FIVE ESTUARIES OFFSHORE WIND FARM

Appendix M4 to the Natural England Deadline 4 Submission

Natural England's comments on the Examining Authority's Written Questions 2 [PD-014]

Planning Inspectorate Reference EN010115

DRAWING NUMBER: **5.1**

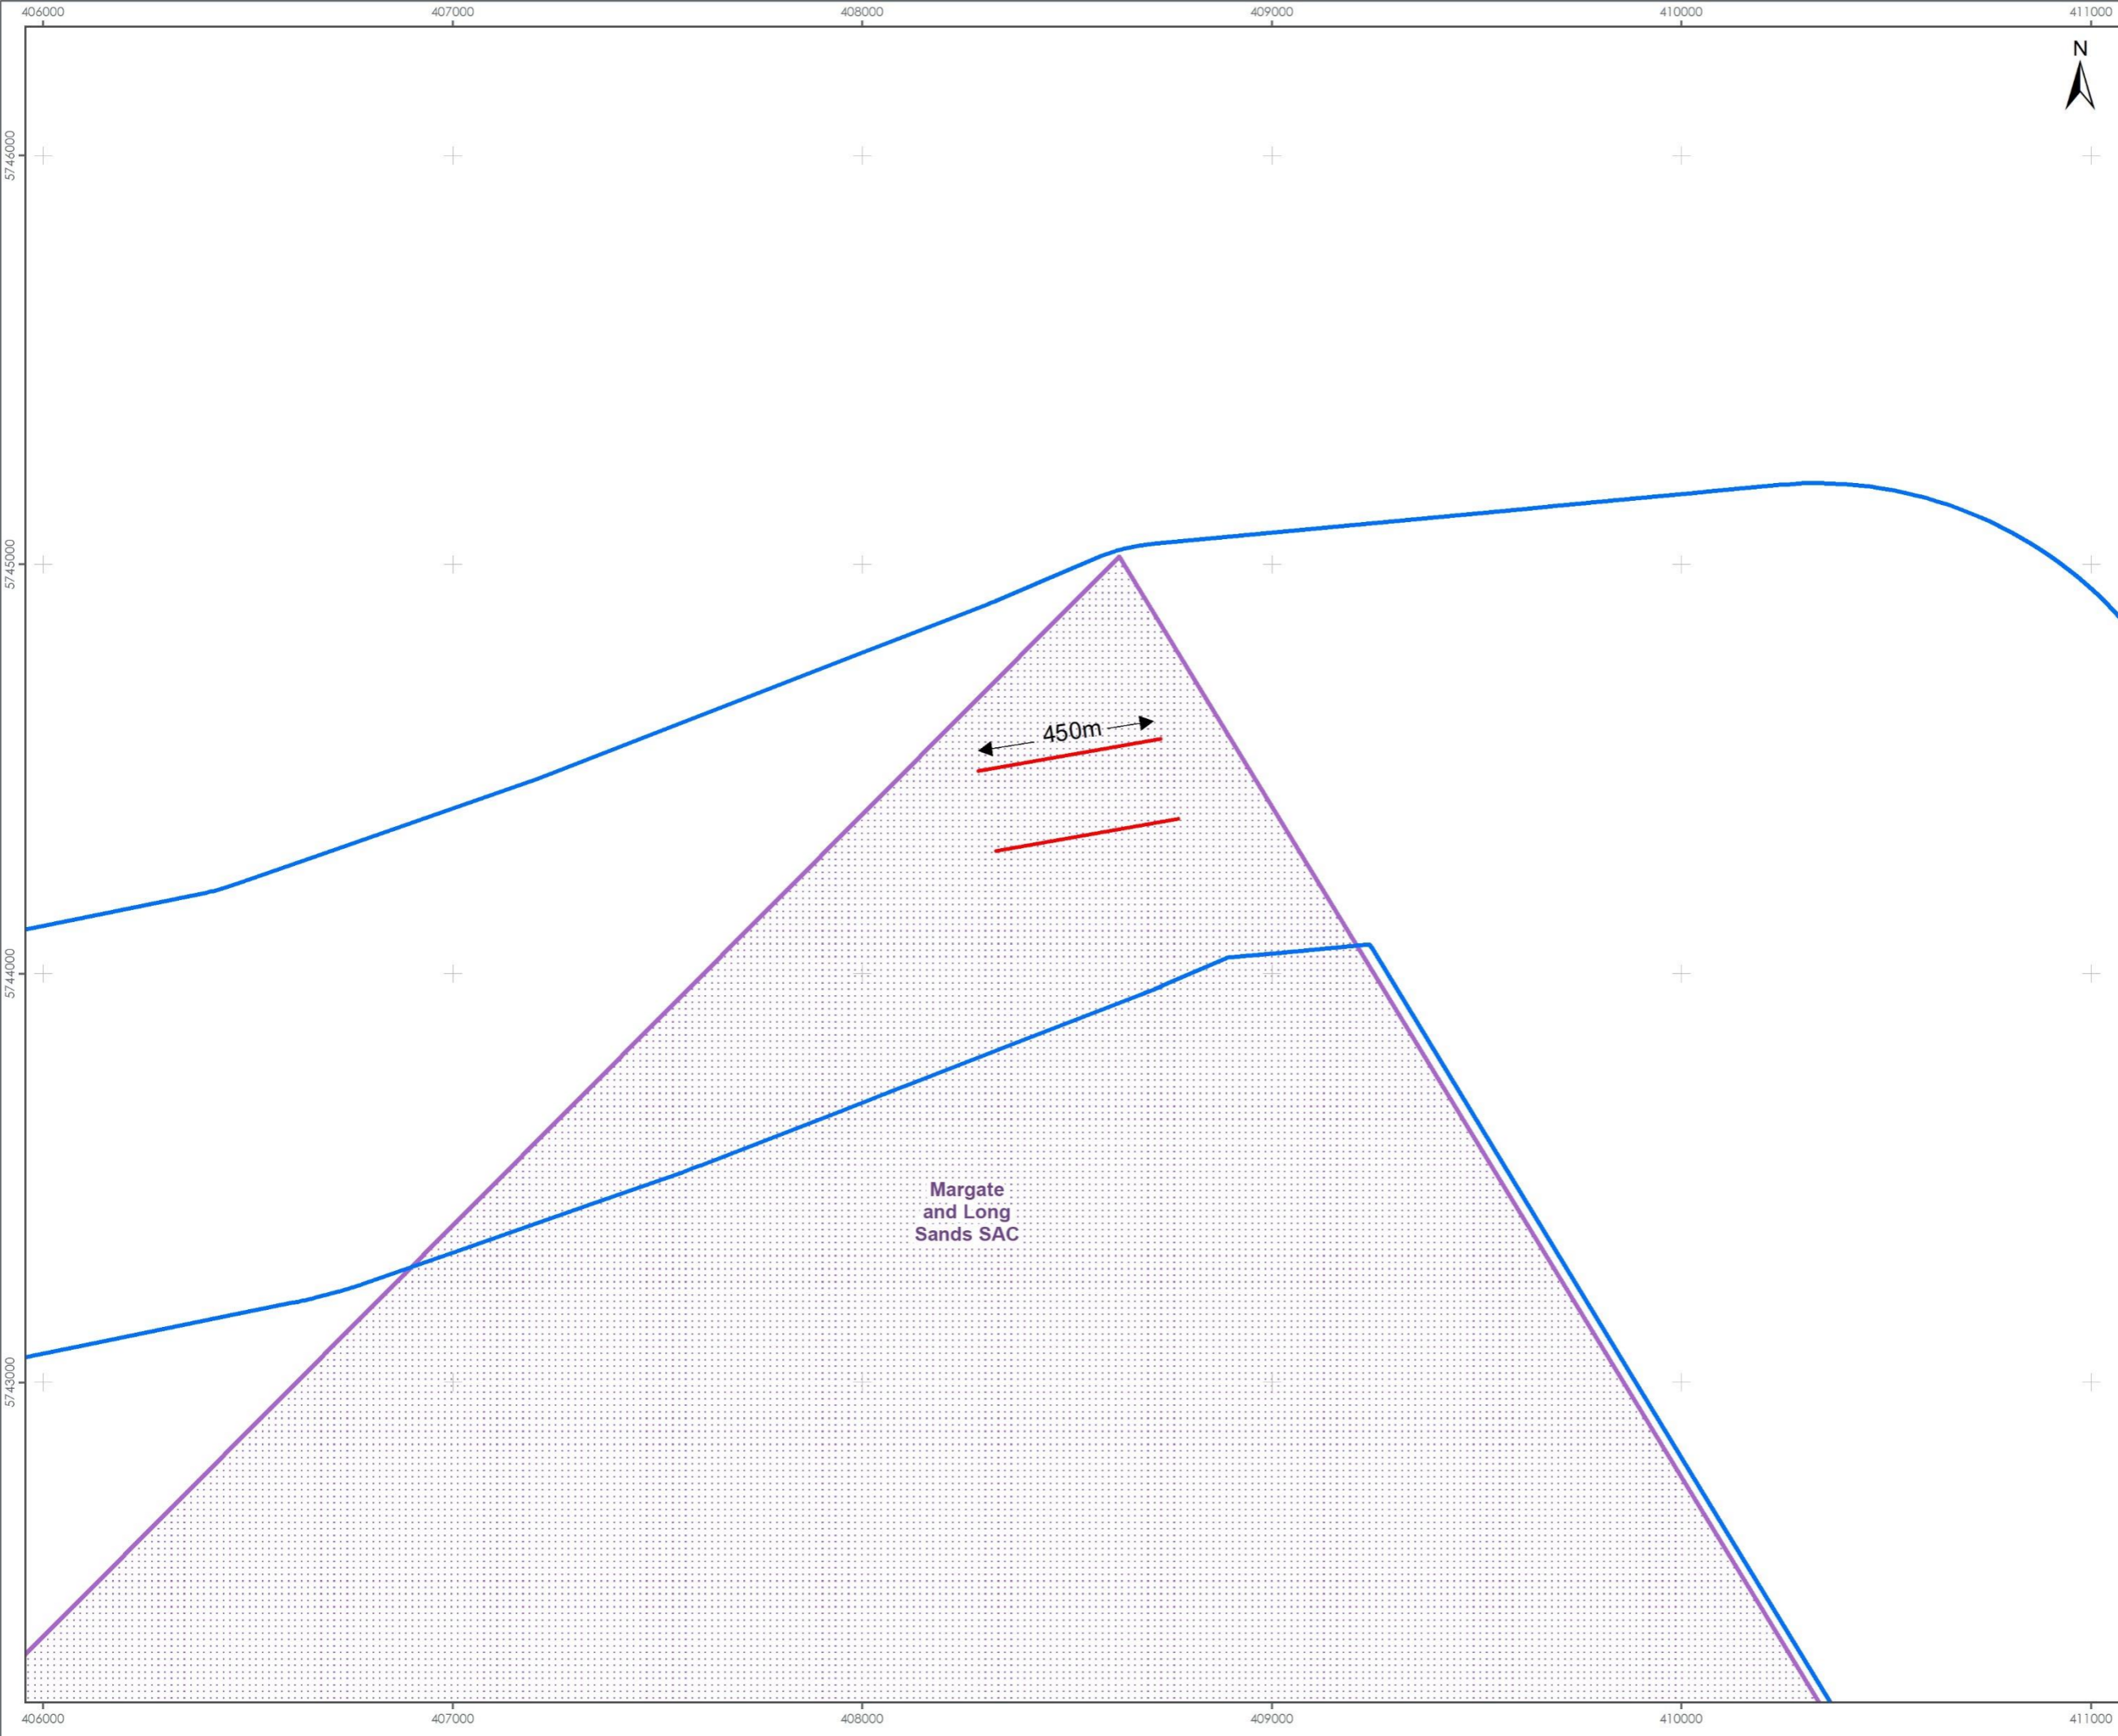
Question to:	Question	Natural England Response
Marine Ecology (ME)			
Benthic Ecology			
ME.2.02	Natural England	<p>Technical Note – Methodology for Determining Maximum Design Scenario</p> <p>The Applicant has provided a Technical Note – Methodology for Determining Maximum Design Scenario (Offshore) [REP2-027]. Is Natural England content with what is stated in that technical note? If not, by Examination Deadline 4 identify any outstanding concerns and explain why you have those concerns.</p>	<p>Please be advised that Technical Note – Methodology for Determining Maximum Design Scenario (Offshore) [REP2-027] doesn't allay our concerns. We hope the following explanation as to why is helpful to the ExA and the Applicant.</p> <p>Natural England advises that [REP2-027] Methodology for Determining MDS Technical Note still does not explicitly state whether the MDS area of cable protection within MLS SAC of 5,400m² includes any scour/cable protection which may be required as a result of cable repair and/or replacement during the O&M phase of the project. If the MDS value for scour/cable protection does include O&M requirements, any assumptions used in the determination of this MDS value should be provided.</p> <p>There are also inconsistencies between [REP2-027] Technical note - Methodology for Determining MDS (Offshore) and the [REP2-021] 9.13 Margate and Long Sands Special Area of Conservation Benthic Mitigation Plan - Revision B (Tracked) with regards to the MDS length of cable protection placed within MLS SAC i.e. 900 m per cable vs 900 m in total. We advise that this should be clarified.</p>

**Figure 4 Sediment dispersal during jetting (IMCA Code of Practice for Offshore Cable Laying in the Renewable Energy Industry M264 Rev. 0.1 – November 2023)**

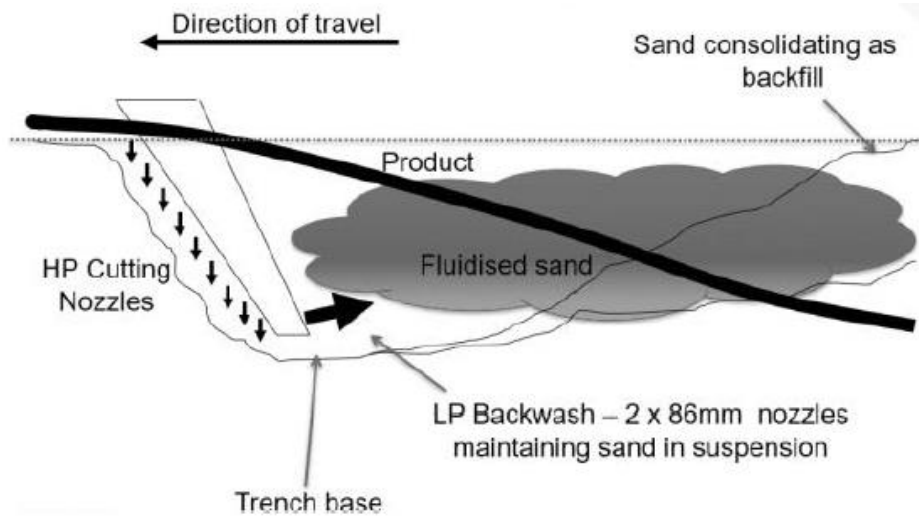
<p>No additional detail has been included that adds certainty that the cables can be buried. Further detail should be provided to give more certainty or clarity on this issue.</p> <p>Natural England notes that, in the MDS Technical Note [REP2-027], Section 2.4.2, the Applicant states that a 50% sediment disturbance has been used for trial trenching (Table 1.6) which seems to contradict [REP1-051] in which the Applicant confirms use of the assumption that up to 100% of material will be fluidised and displaced from the trench. We advise that this needs to be clarified.</p> <p>We also note in the MDS Technical Note [REP2-027] that "only very minor changes are expected to the sediment transport regime at MLS SAC due to the presence of cable protection", this conclusion needs to be supported with more evidence, such as a detailed sediment transport modelling study, based on the prevailing conditions at the proposed cable protection site.</p>
